COUNTY COUNCIL'S RESPONSE TO CONSULTATION ON THE FOLLOWING DEVELOPMENT PROPOSAL

Application No: 18/00584/REM

Proposal: Reserved matters application to 15/01012/OUT - Development of up to 48,308sqm of employment floorspace (Class B1c, B2, B8 and ancillary B1a uses), the siting of buildings to the south of the site, servicing and circulation areas, vehicular and pedestrian access from Skimmingdish Lane and landscaping

Location: Land North East Of Skimmingdish Lane Launton

Drwg No
 17007 / TP / 1003

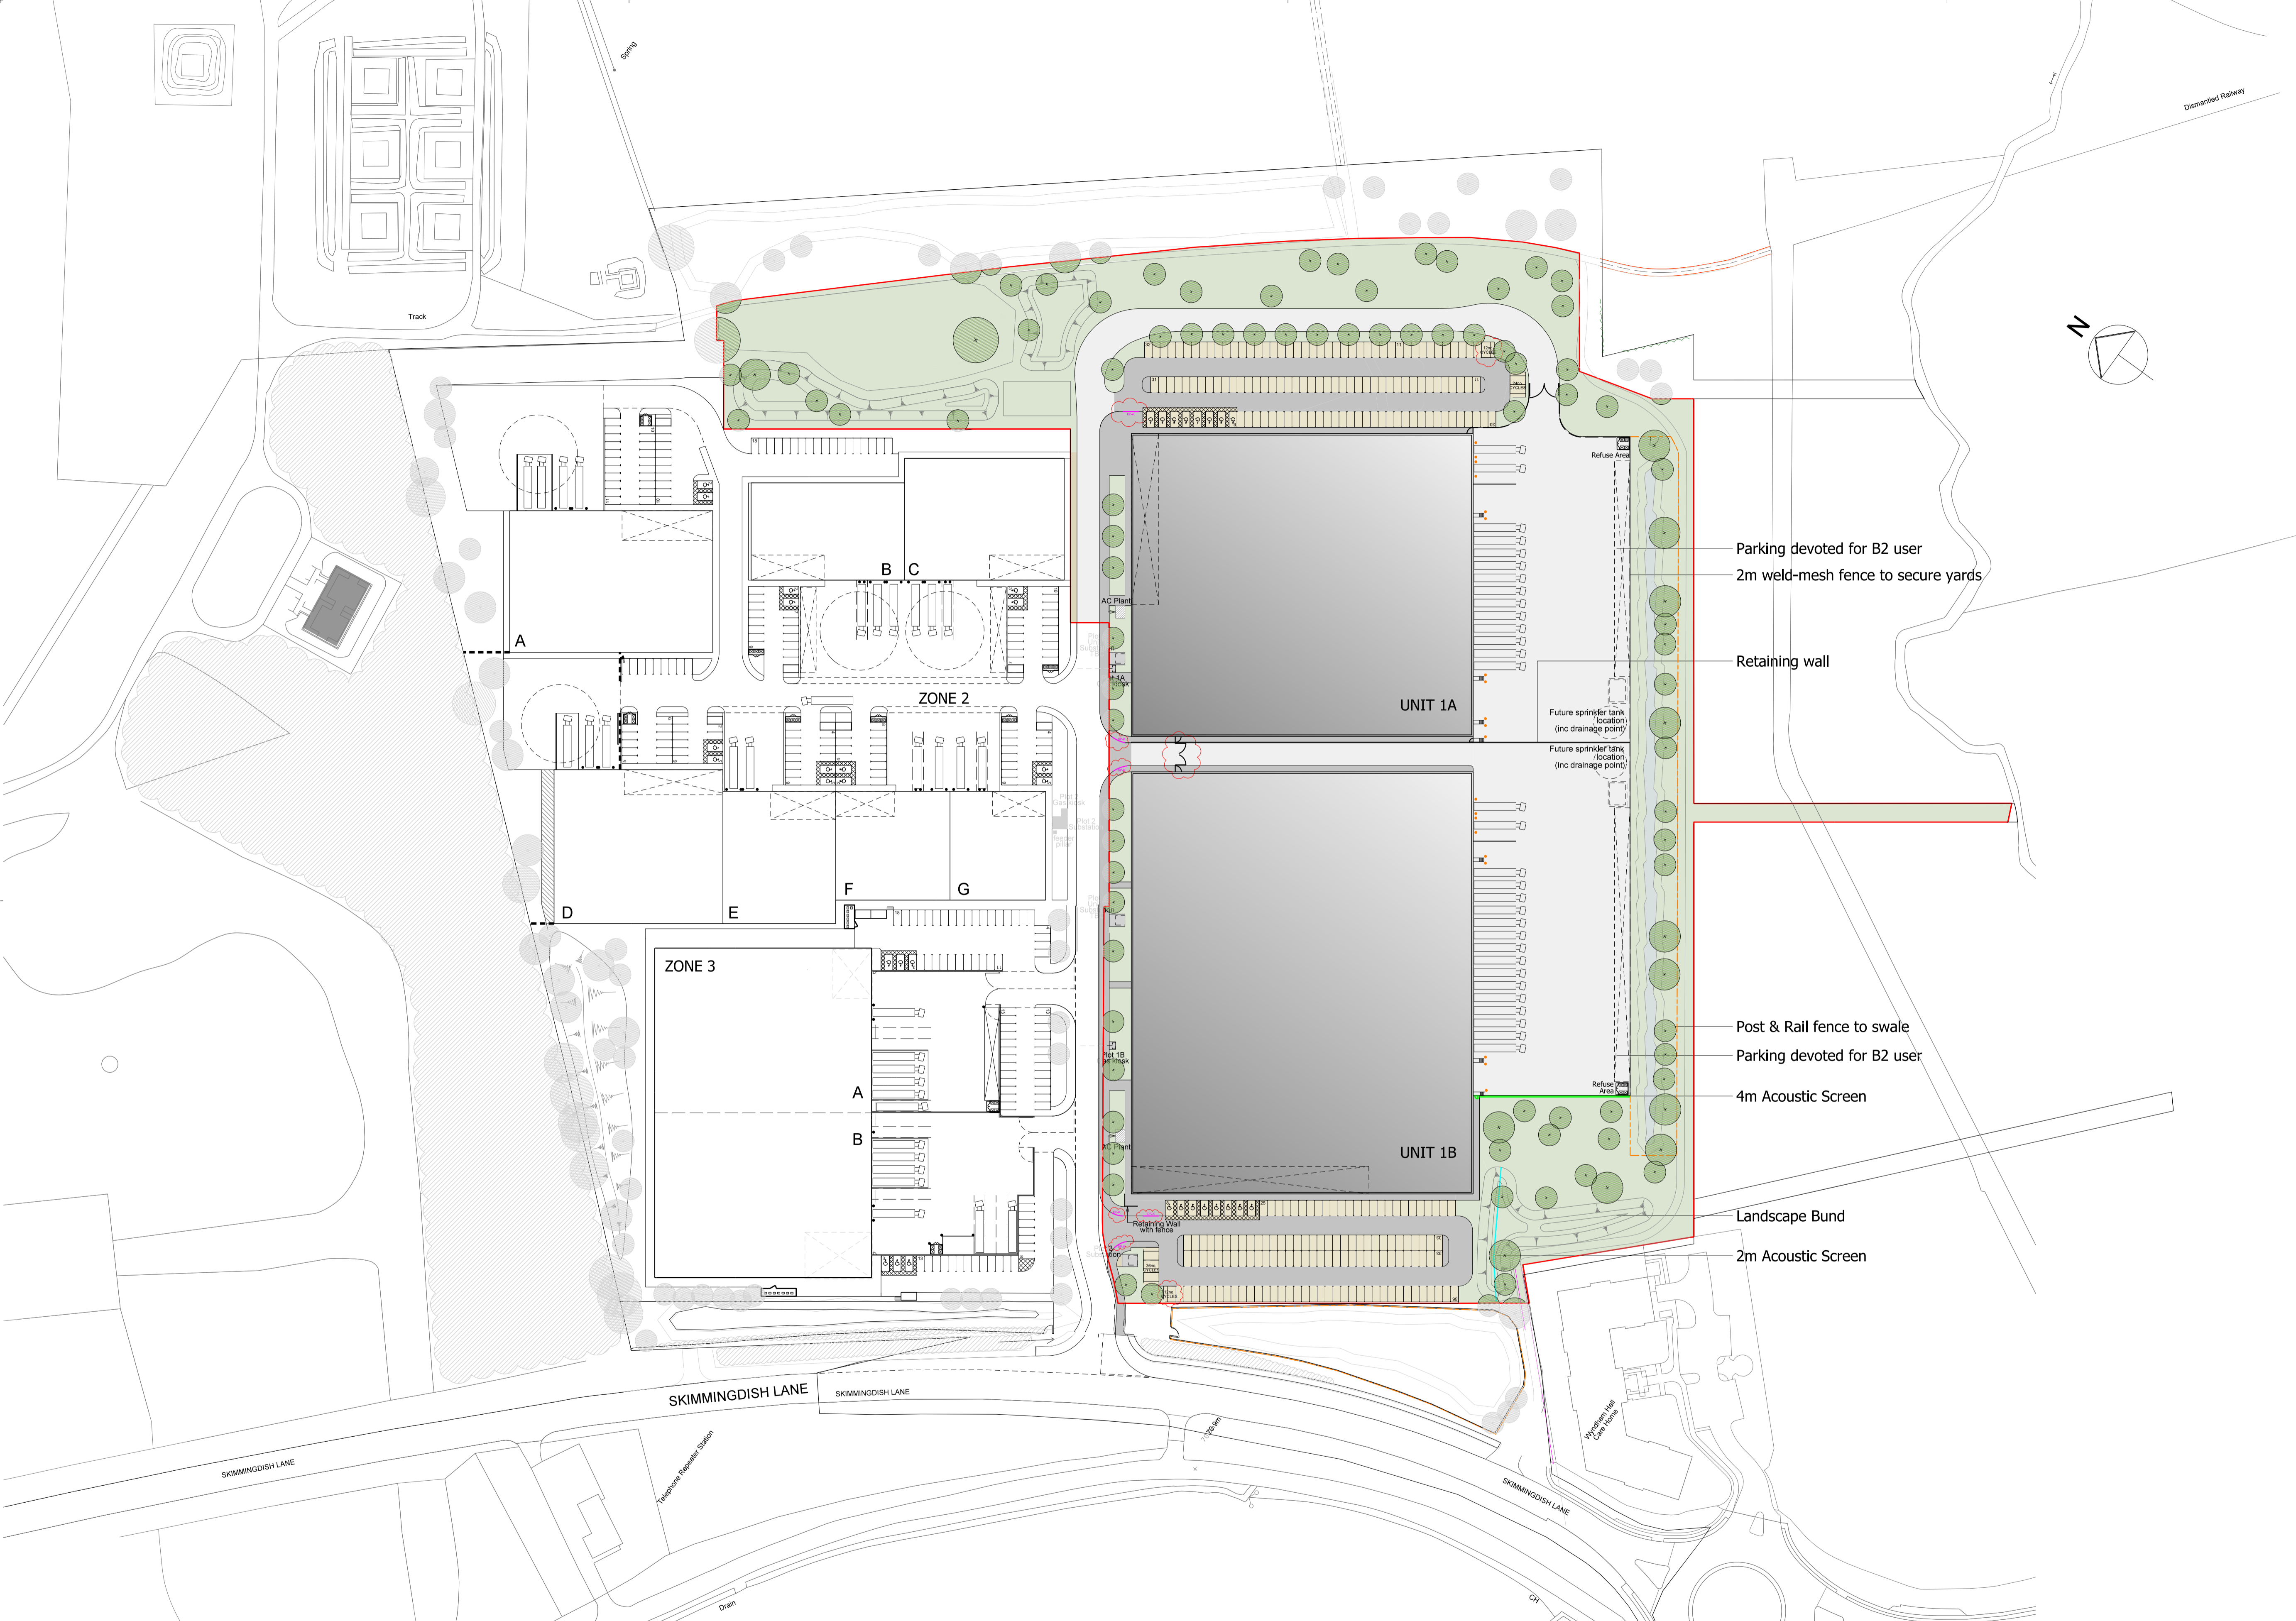
- Conflicting information on the number of cycle parking spaces
- Number of cycle spaces shown on design drawings is inadequate
- Footways must have suitable dropped kerbs and tactile surfacing at crossing points
- Gate on access road between Units 1A and 1B to be relocated

Both car parks are laid out in long rows with two aisles. Drivers entering the car parks will inevitably seek to find a space as near to the building entrance as possible, and will naturally use both aisles rather than stick to a one-way circulation. If it is the intention to have a one-way system, then appropriate signage and white-lining will be required, and possibly some form of barrier or gate.

There is a gate at the north-western end of the access road between the Units. Should this gate be closed, then any incoming HGV will need to lay-up in the spine road, causing an obstruction to other traffic. Furthermore, if an HGV was waiting to exit the site once the gate had opened, an HGV parked on the spine road is likely to obstruct the left-turn movement out. It is recommended that the gate is relocated to the south-east in order to accommodate at least one HGV in the access road, to reduce the likelihood of blocking/obstructing the spine road.

There is some inconsistency in the information relating to cycle parking provision. The Proposed Site Plan (Drg. No. 17007 / TP / 1003) and other drawings label 24no. cycles for each unit, as stated in 3.15 of the Reserved Matters Report. However, the Parking Note in Appendix 2 of the same Report states that there will be 24 **hoops** per unit, i.e. storage for 48 cycles per unit.

Informal crossing points between each section of footway should have dropped kerbs and tactile surfacing, to accommodate all pedestrian users.
